Application for a Non-Material Amendment Following a Grant of Planning Permission

Single storey side extension and garage conversion

PL/2023/02512/MINFHO

Changes to fenestration on side elevation

PROPOSED SIDE - N-E

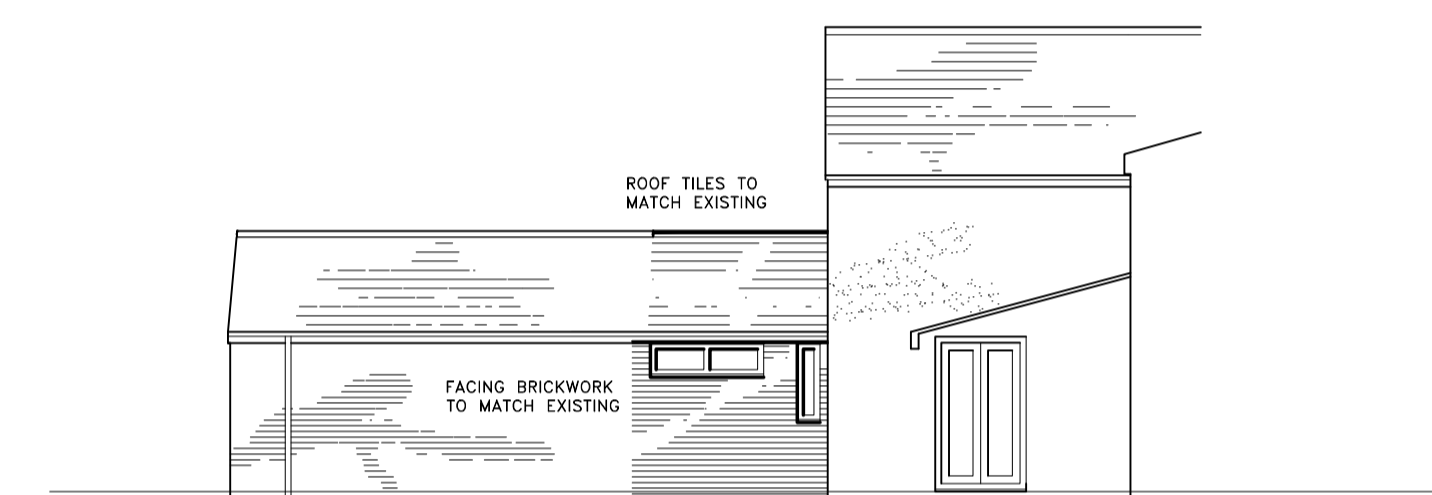
Client amended floor plan so fenestration change is required
